Re: 30 Merrill Street

17 October 2016

1 FRONT (EAST) ELEVATION
SCALE: 1/4" = 1'-0"

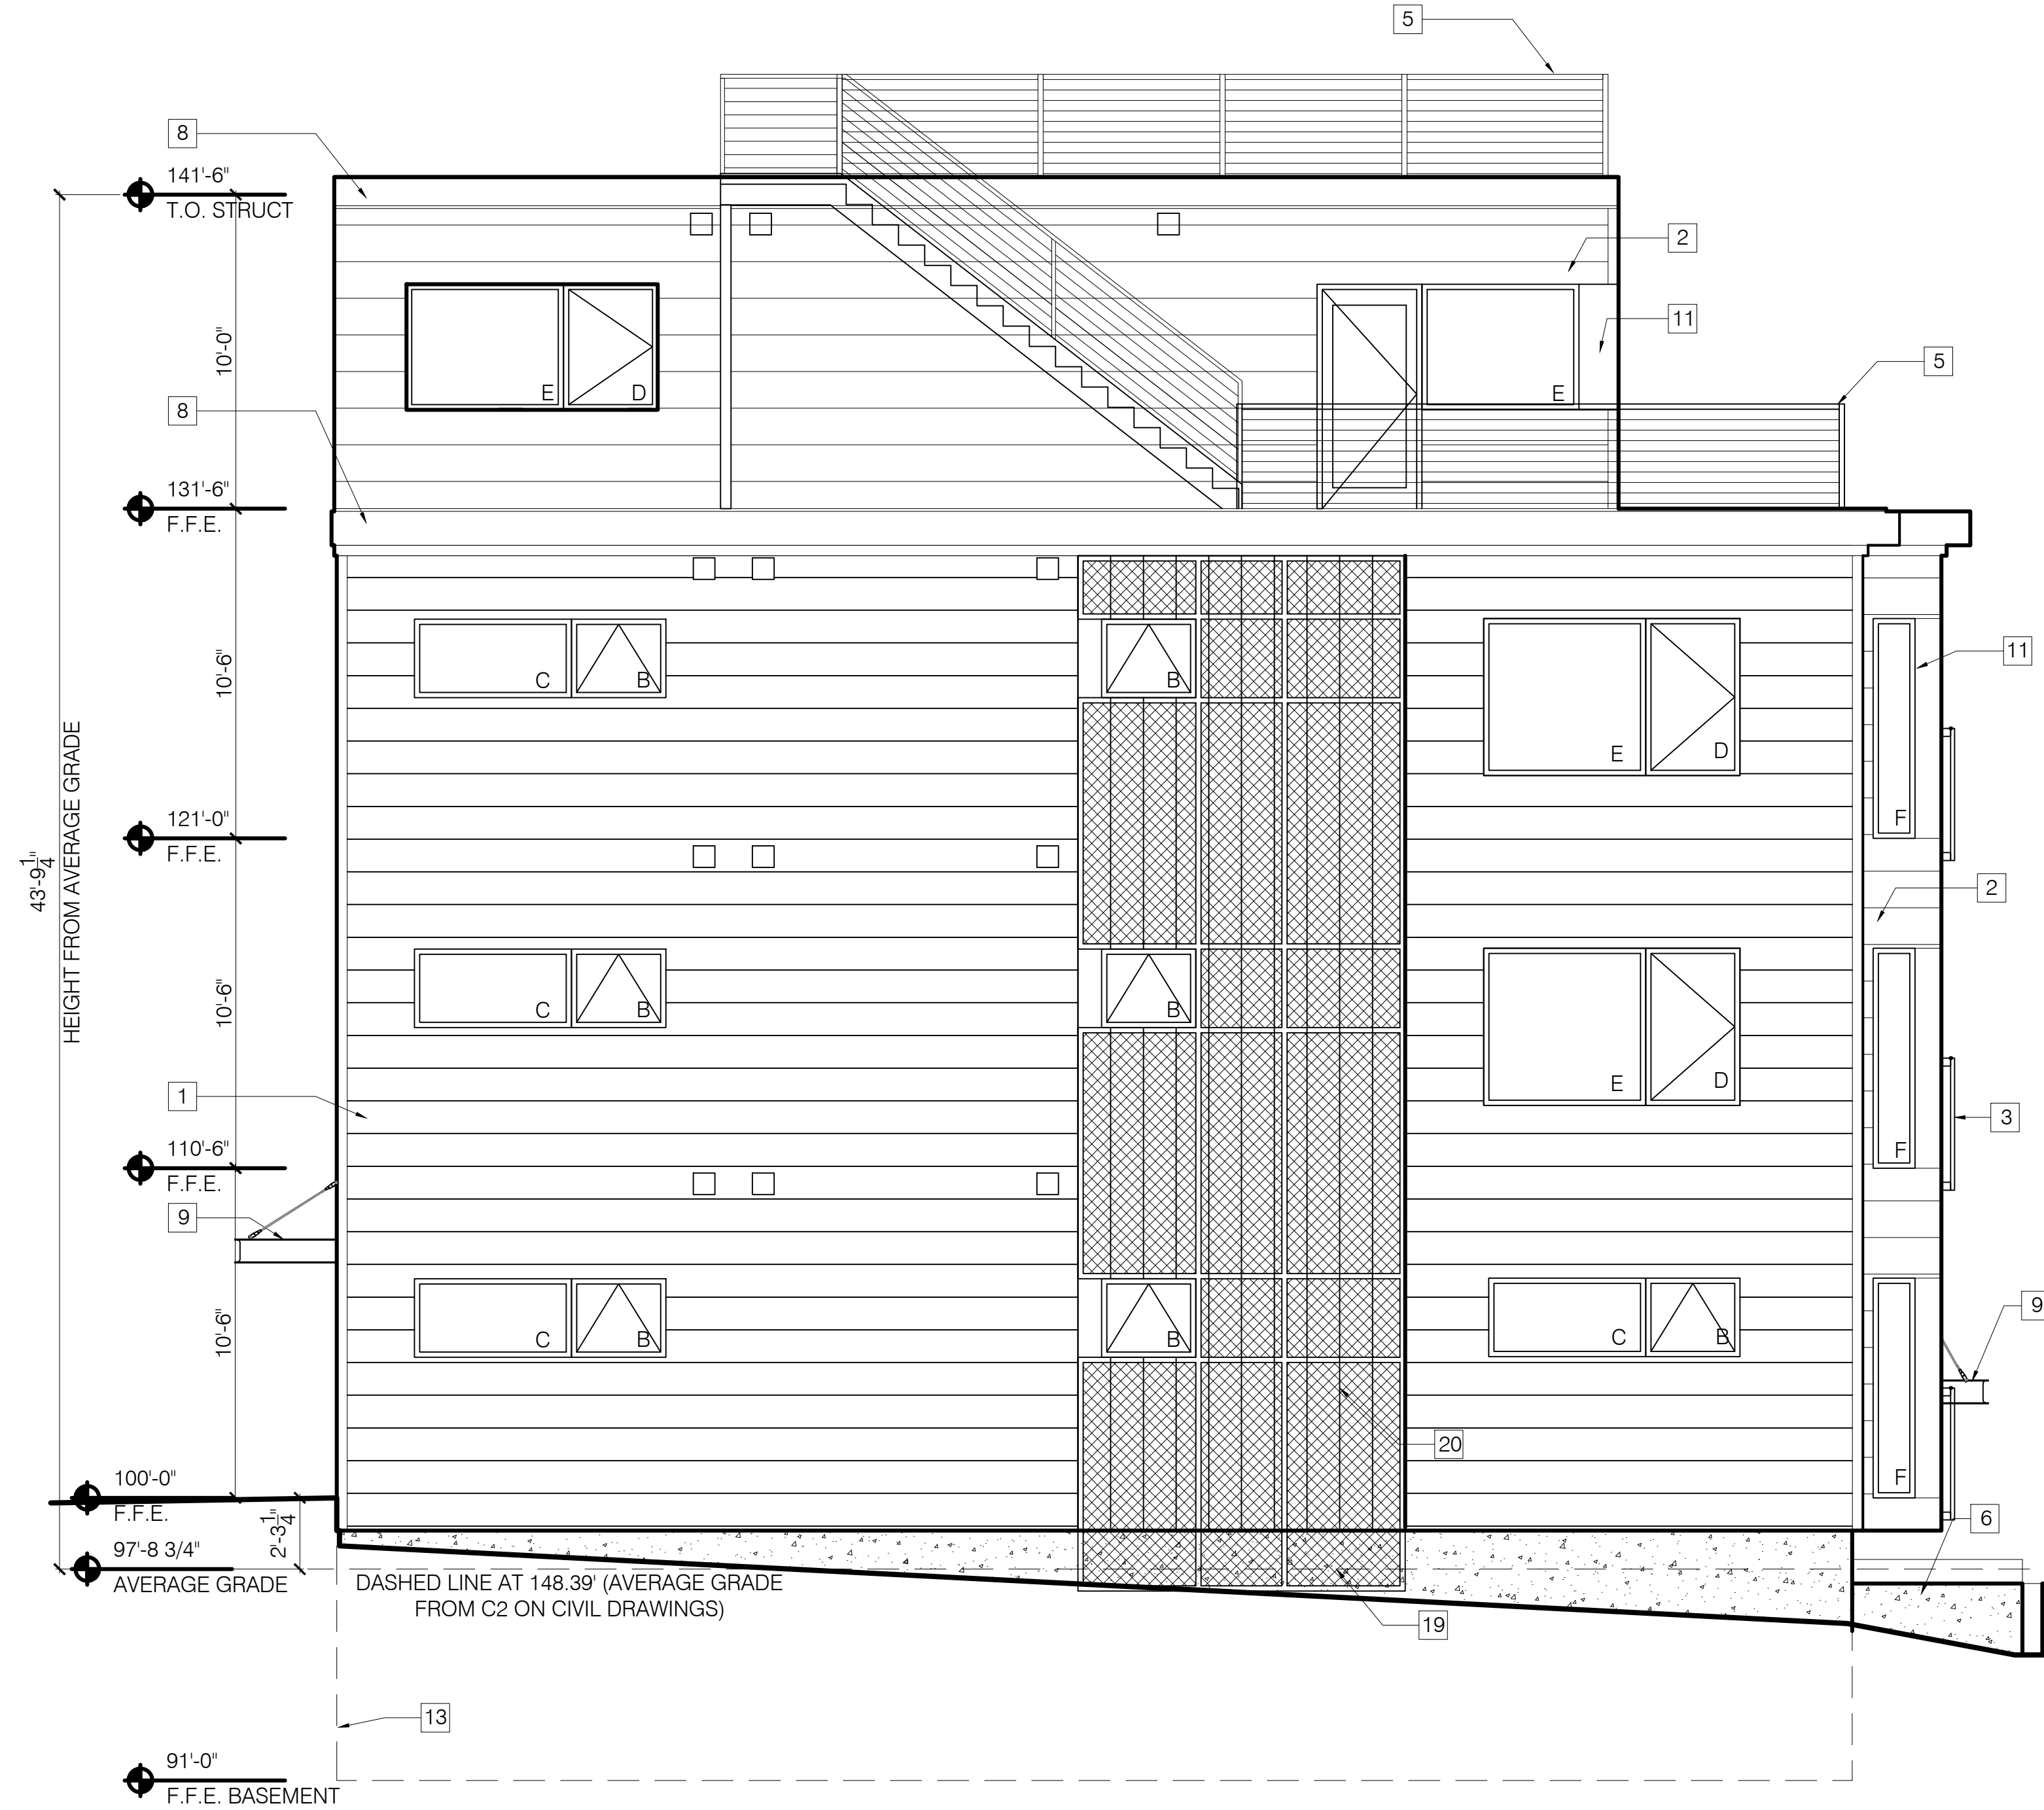
Still, in "the real world of human occupancy": how will he defend the slightly altered, but unimproved, "front door"? Or the now-vertical windows that don't appear to function -- i.e., open and close? Would double-hungs, much more in keeping with the neighborhood, really break the bank?

My opinion: The revised rendering is even worse than the original design. The blank middle with its sad square portholes is too wide to balance the boxy bump-outs on either side. The side view is, from what I can see, as bricklike as it was in the earlier iteration.
